SCHEDULE OF PLANNING REVISIONS FOR NMA

PROJECT **higgi haus - 57-59 St Mary's Street Cardiff**
 ISSUE DATE **18/12/2023**
 REVISION

Proposed amended Basement plan
HH SS GA 100 PLAN_BASEMENT

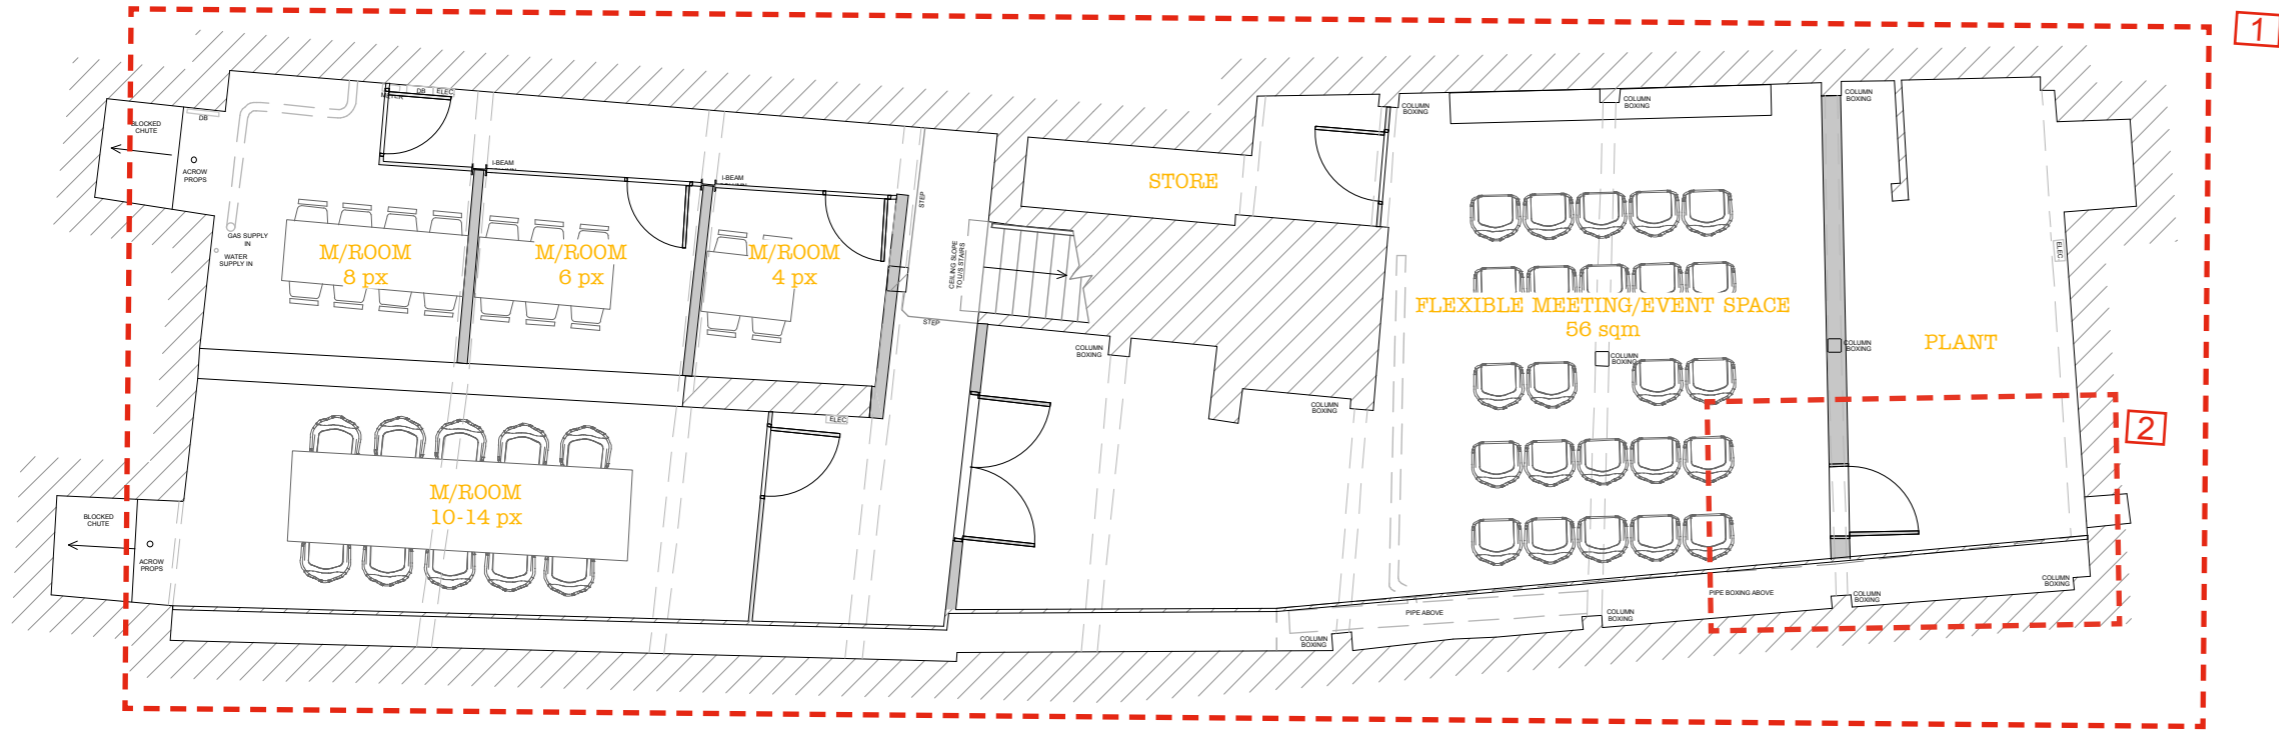
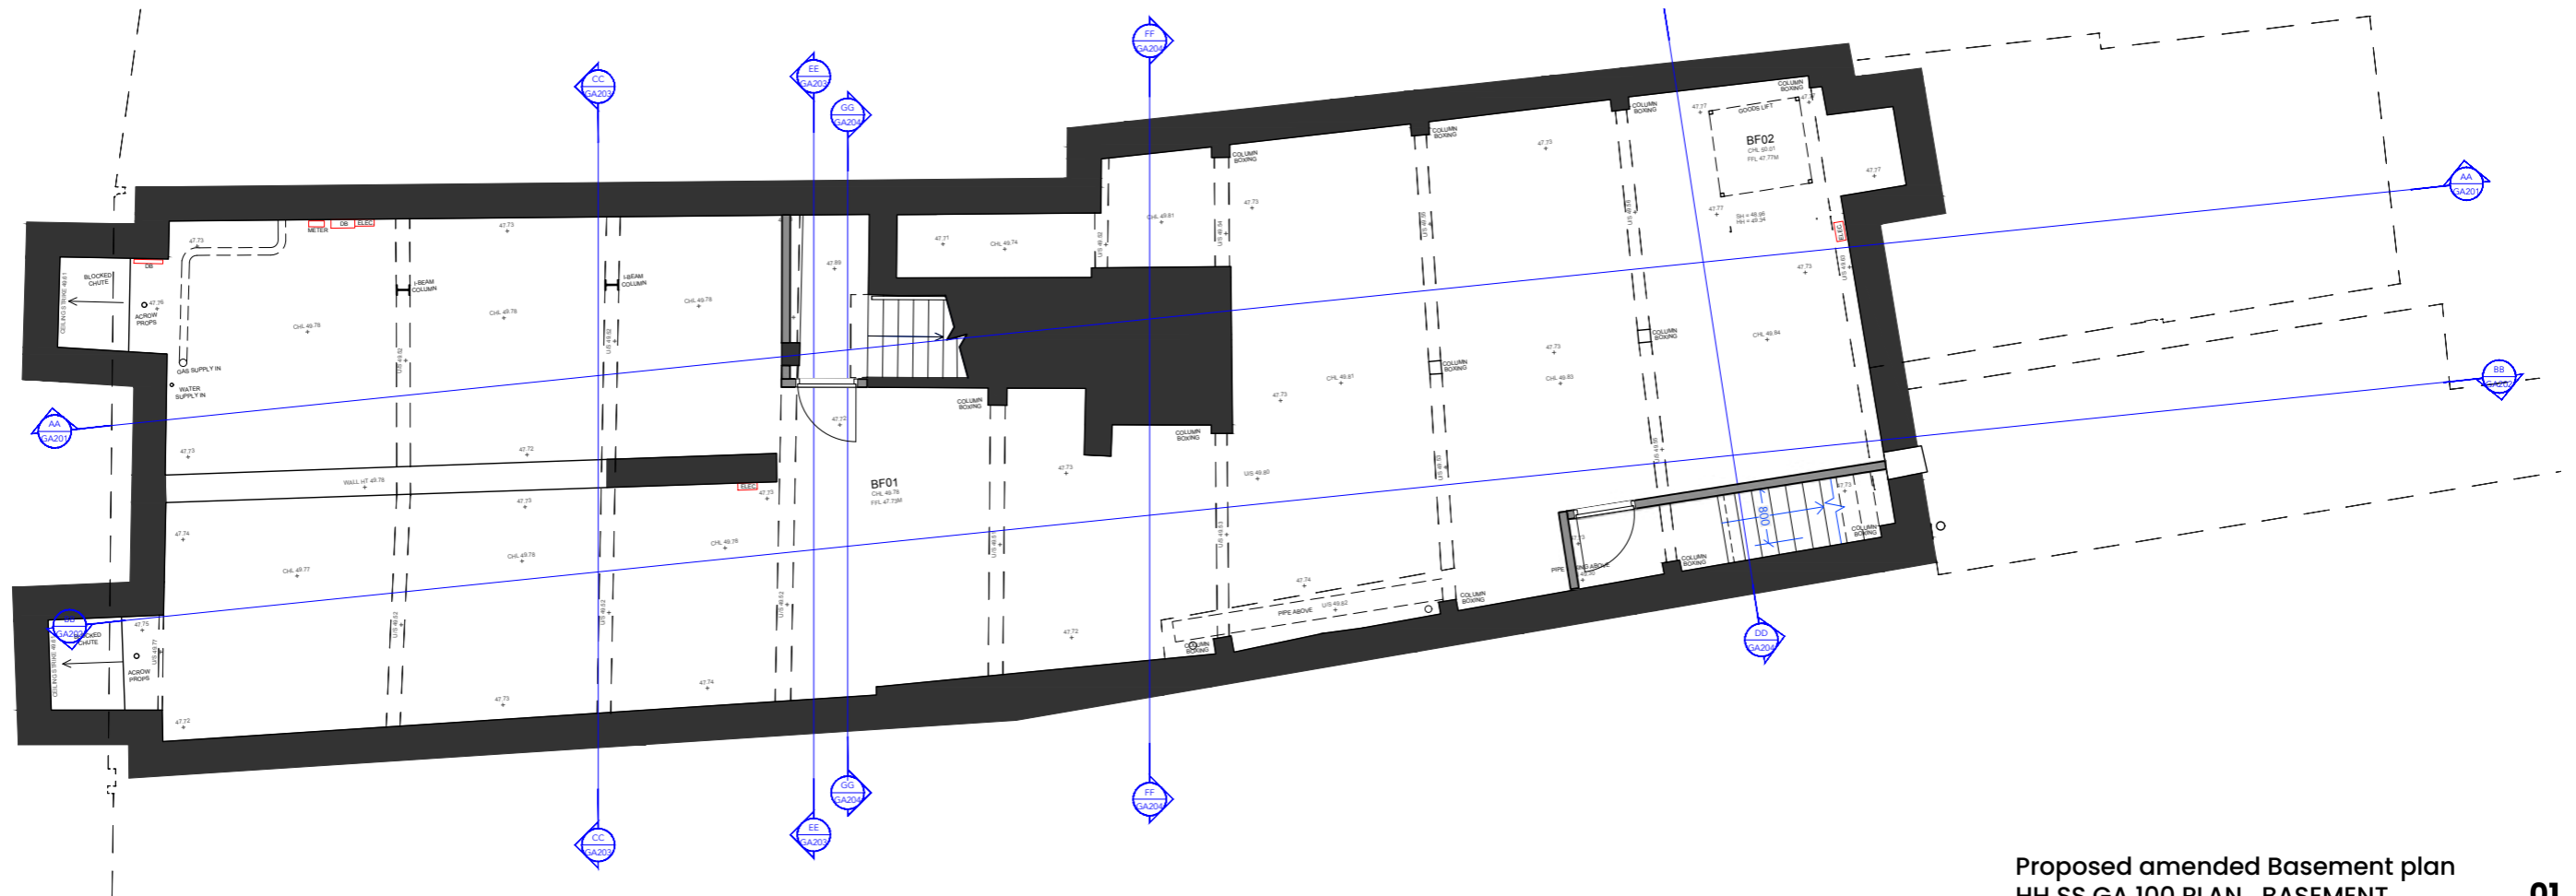
Drawing number	Drawing title	Rev number	Drawing number	Drawing title	Rev number	Key #	Comments
PAGE 01	JHHSMS/008/P3	Basement GA Proposal	P3 04.10.21 Planning Application Issue	HH SS DM 100 PLAN_BASEMENT	BASEMENT PROPOSED GA PLAN	NMA Issue 12/12/23	1	Removing of all internal layout. Basement to remain unoccupied except for storage of coworking space
							2	Addition of a new fire exit stair from basement level to rear alleyway at Ground Floor level.
Page 02	JHHSMS/009/P5	Ground Floor GA Proposal	P5 - 26.05.22 Updated plan (bike storage)	HH SS GA 101 PLAN_L0	GROUND FLOOR PROPOSED GA PLAN	NMA Issue 12/12/23	1	Relocation of co-working space entrance for seperarated residential entrance + Reinstatement of a central double galzed door to shopfront façade
							2	Removal of bike storage and relocation of kitchen area
							3	Removal of residential access to basement level. Basement only accessible from co-working space for storage use.

Proposed amended Ground floor plan
HH SS GA 101 PLAN_LO

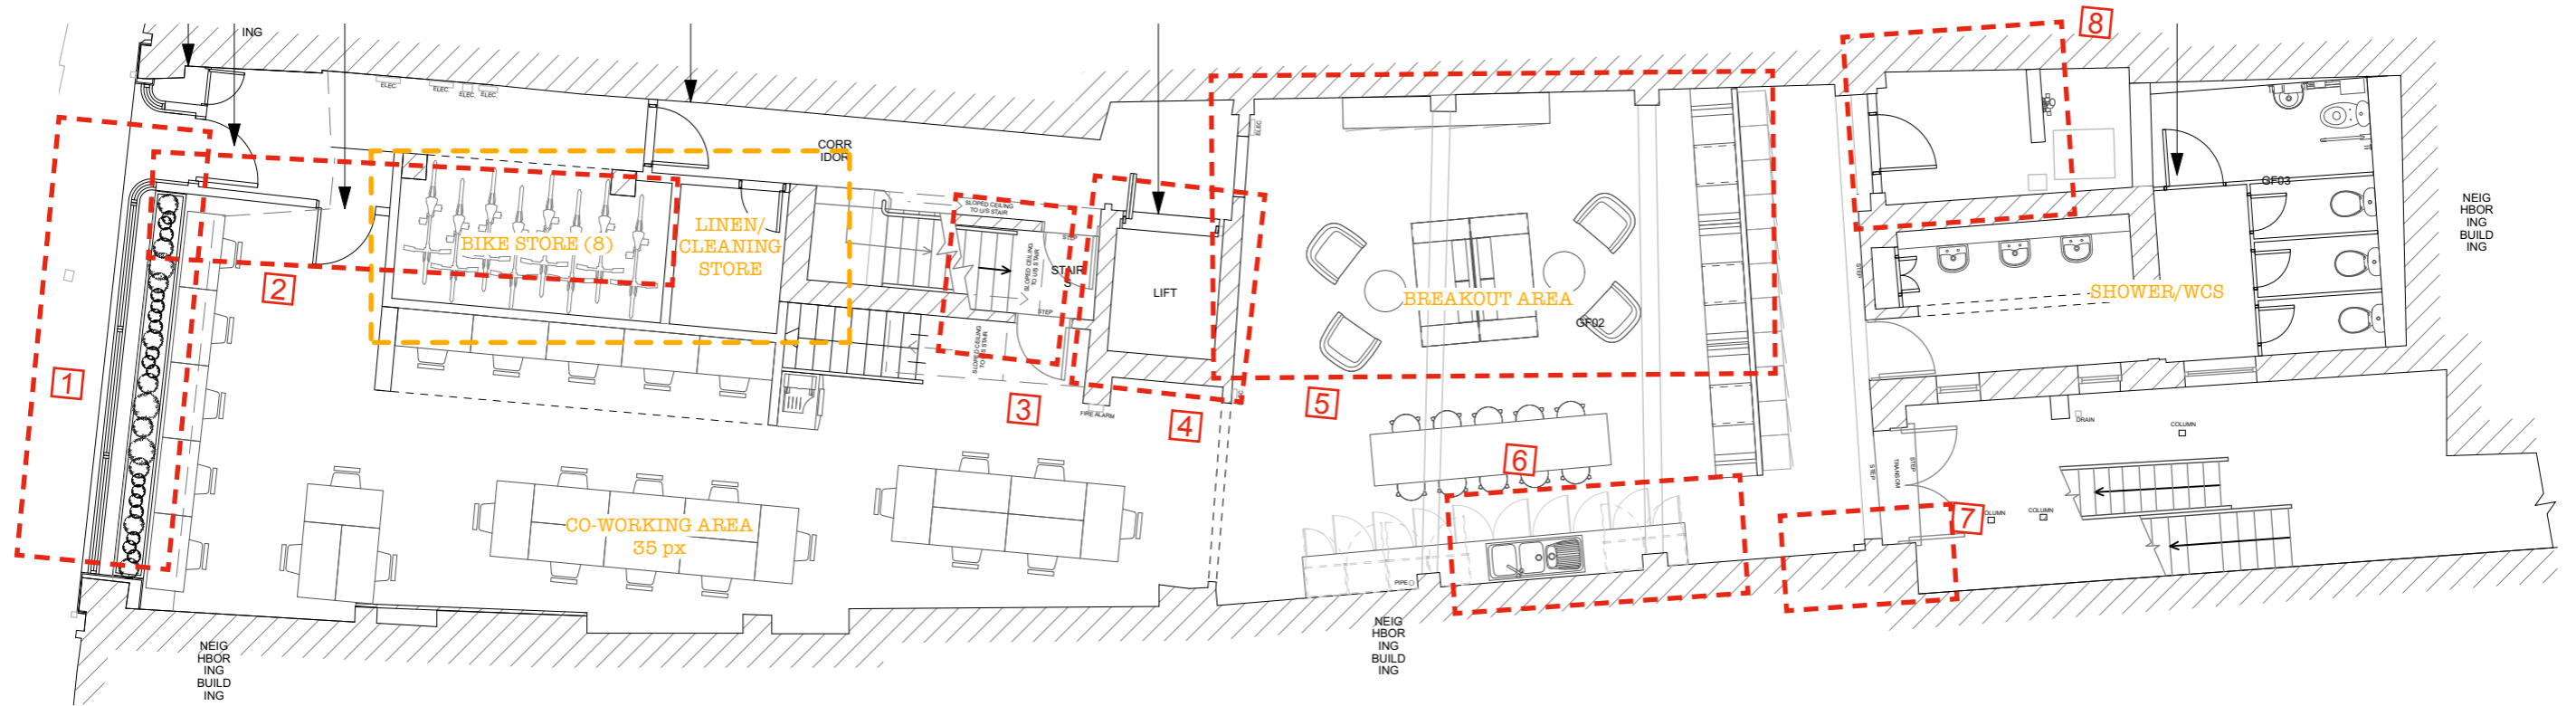
4	Removal of proposed new residential lift. Existing empty lift shaft to be converted into emergency smoke shaft.
							5	Bike storage relocated to underside of mezzanine
							6	Addition of a new fire exit stair from basement level to rear alleyway at Ground Floor level.
							7	Removal of existing external metal stairs at rear of building
							8	New shower cubicles layout
Page 03	JHHSMS/010/P3	First Floor GA Proposal	P3 04.10.21 Planning Application Issue	HH SS GA 102 PLAN-L1	FIRST FLOOR PROPOSED GA PLAN	NMA Issue 12/12/23	1	Removal of proposed new residential lift. Existing empty lift shaft to be converted into emergency smoke shaft.
							2	Window infilled to unable lightwell extension
							3	Suppression of balcony New proposed 8.5sqm extension into lightwell (applicable to 1st, 2nd and 3rd floor)
							4	Suppression of balcony Adjustment of window layout to allow bathroom extension of 1F02 into ventilated lobby whilst maintaining minimum 1.5sqm automated smoke vent window.

Proposed amended First floor plan
HH SS GA 102 PLAN-L1

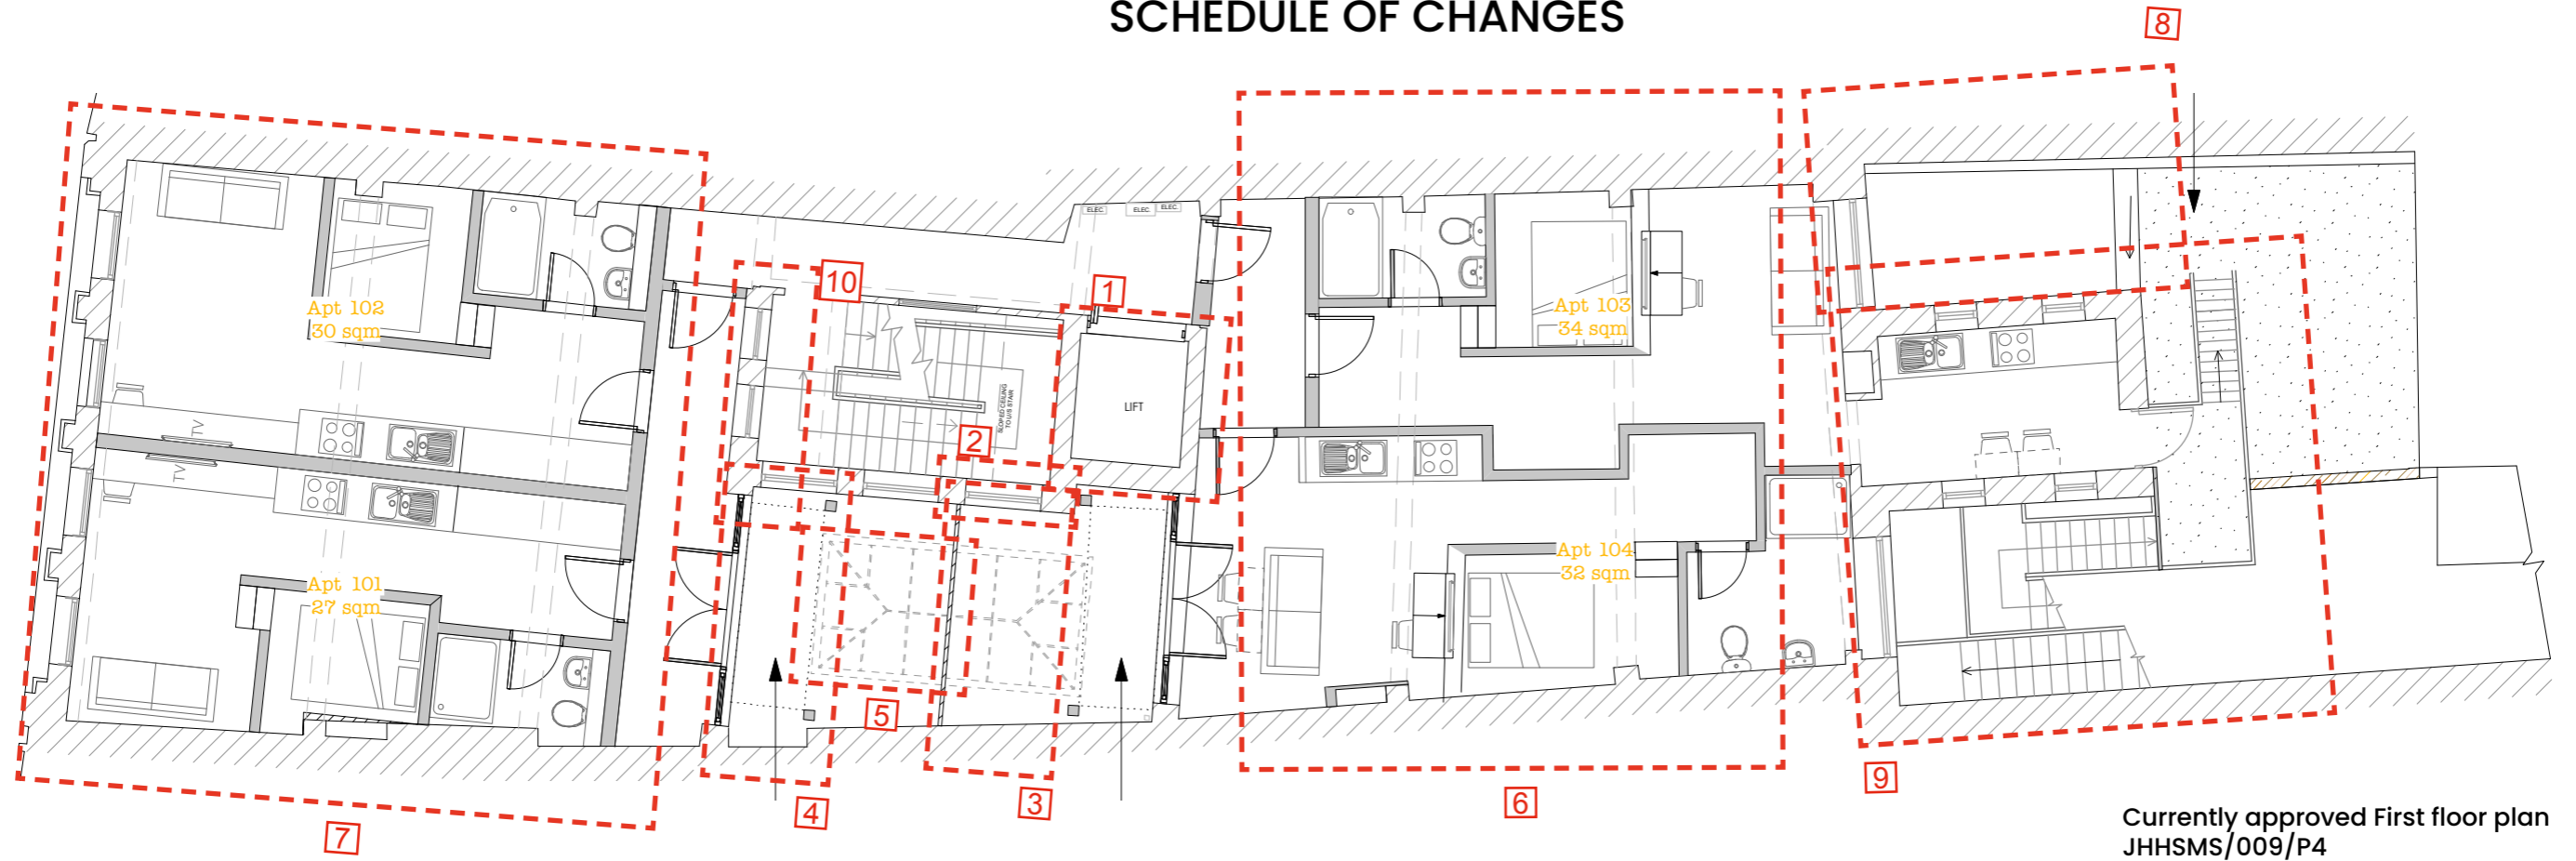
5	New lightwell skylight
							6	General revision of internal layout to accommodate 3 residential unit (previously 2)
							7	General revision of internal layout
							8	Removal of external roof terrasse
							9	Removal of existing external metal stairs at rear of building Kitchen relocated and replaced with bedroom + study
							10	Infill of stairwell windows
Page 04	JHHSMS/011/P3	Second Floor GA Proposal	P3 04.10.21 Planning Application Issue	HH SS GA 103 PLAN-L2	SECOND FLOOR PROPOSED GA PLAN	NMA Issue 12/12/23	1	Removal of proposed new residential lift. Existing empty lift shaft to be converted into emergency smoke shaft.
							2	Window infilled to unable lightwell extension
							3	Suppression of balcony New proposed 8.5sqm extension into lightwell (applicable to 1st, 2nd and 3rd floor)
							4	Suppression of balcony Adjustment of window layout to allow bathroom extension of 1F02 into ventilated lobby whilst maintaining minimum 1.5sqm automated smoke vent window.
